R/221/18/PL

From: Aisha Bird [REDACTED]
Sent: 20 October 2018 21:27
To: Anita Gardner
Subject: ParkView Court

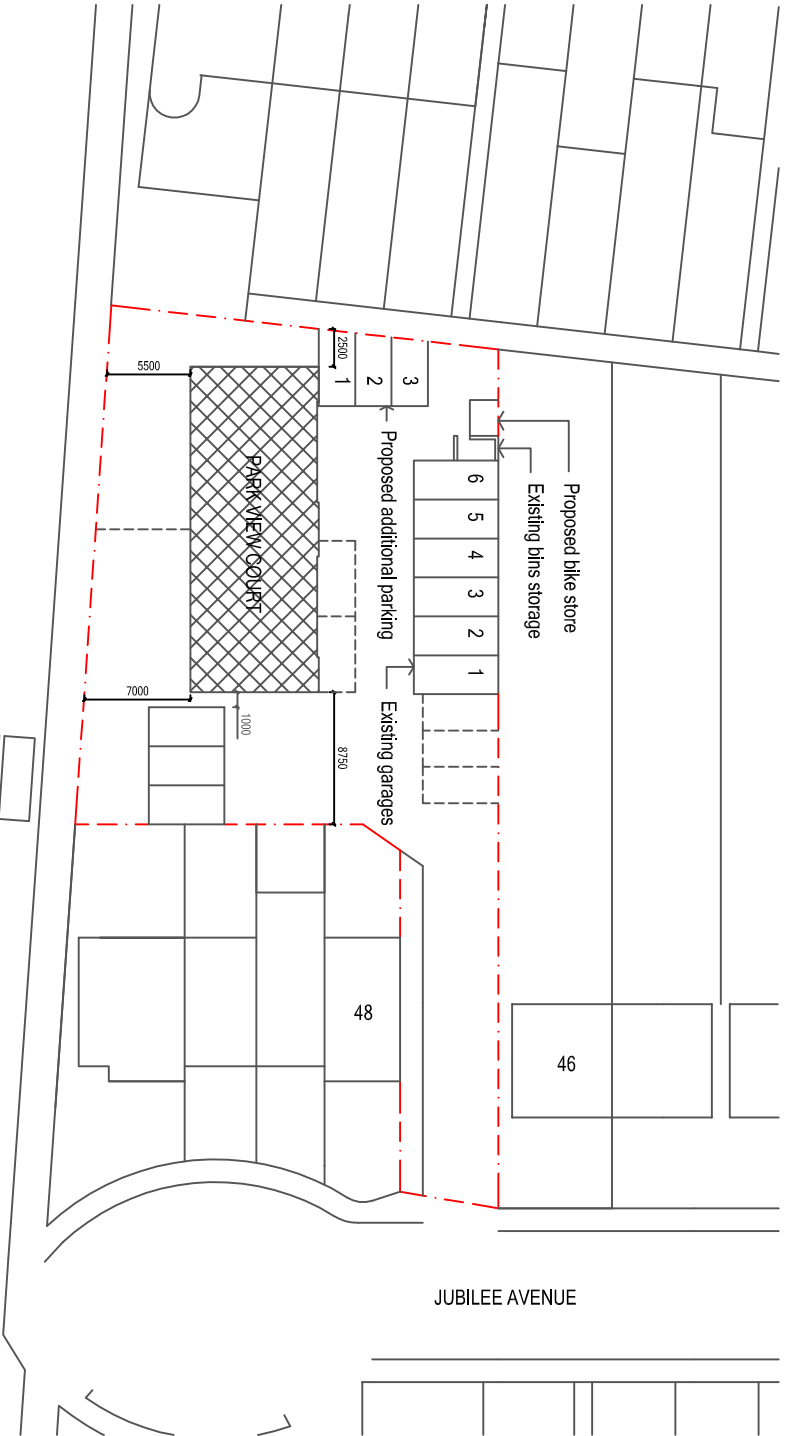
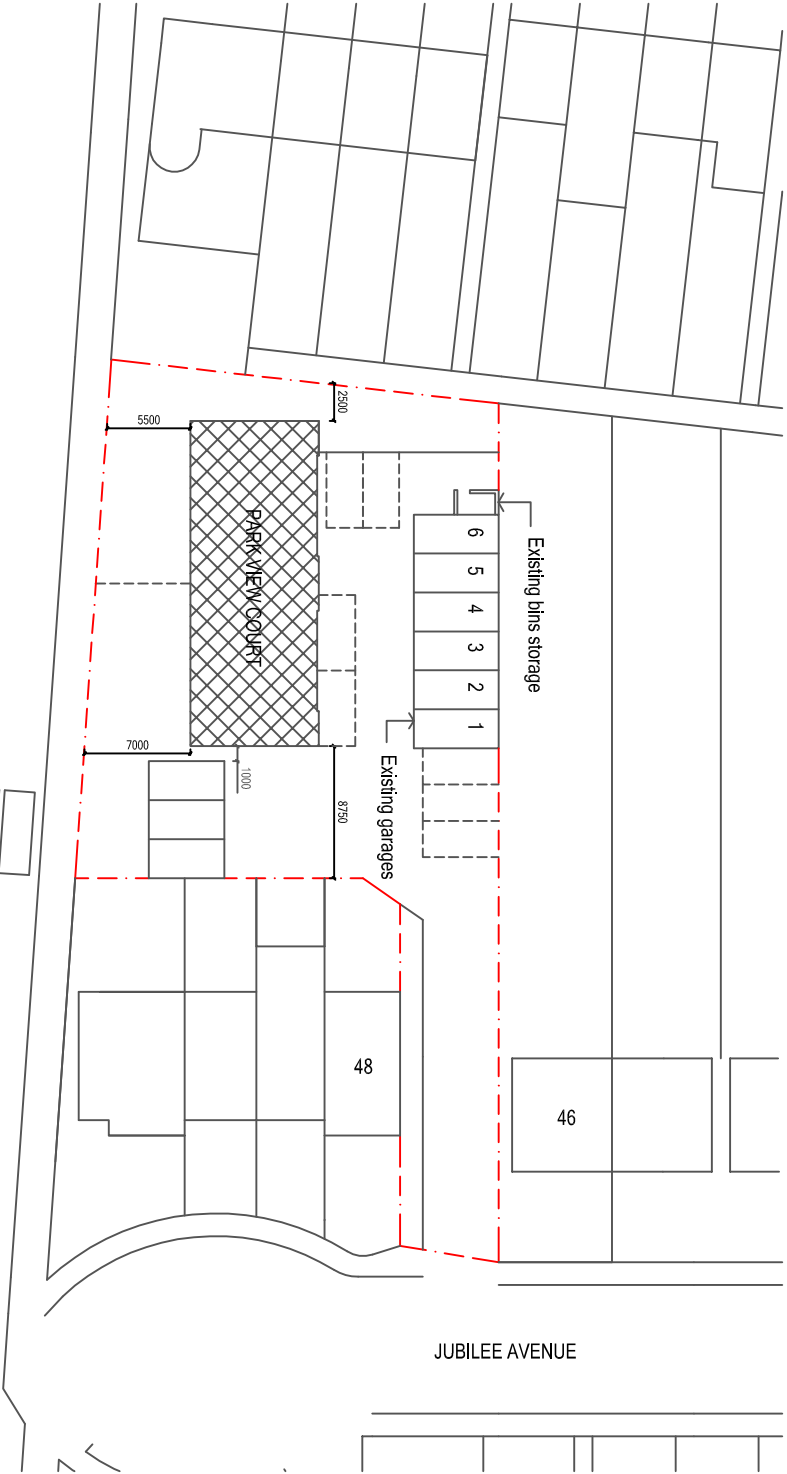
On my current property deeds it is clearly marked there is a communal garden for all tenants/owners to use, if this is to be filled in for the creation of more parking spaces will a revised property plan be issued to me? I am thinking in the future if I ever come to sell my home the plans I have will not match with what is being marketed.

Also my garden with private access opens into the current communal space, I have looked at the plans and cannot see if/how my garden access will be affected, are you able to shed any light on this too please.
